DECISION DELEGATED TO HEAD OF PLANNING

Application No: H16-0688-26 **Applicant:** Rebecca Denaco Alliance

Proposal: Demolition of existing agricultural barns and greenhouse and erection of residential development - approved under H16-0689-24. Amendments to ground floor internal layout and associated elevation changes to make utility and gym space on all plots

Location: Land At Water Lane Nursery Low Road Spalding

Ground Floor Plan

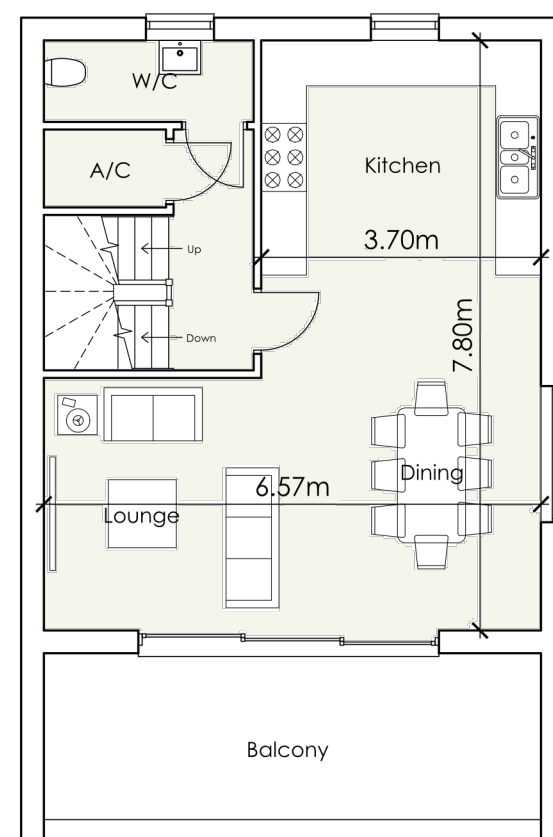
The applicant has provided a series of floor plans (including elevations) that show a gym located at ground floor, with garage-style doors removed on Plots 1, 5, 6, 8 and 9 and replaced with glazed openings.

The applicant seeks to create a gym within the ground floor of all plots. Whilst a gym itself may not be classed as habitable accommodation the condition is explicit in that it allows the ground floors to be used "as a garage, garden store and WC only". The proposed use of a gym is therefore outside of this constraint and such a variation of the condition is considered to be material, and as such cannot be achieved under a non-material amendment.

The proposed change affects Condition 3 to the extent that it would require the condition to be varied. The proposed amendment would therefore result in development that is inconsistent with the extant planning permission. As the proposal cannot be implemented without varying the condition, it would alter the scope of the planning permission itself. Such a change goes beyond the scope of Section 96A of the Town and Country Planning Act 1990 and cannot reasonably be regarded as non-material.
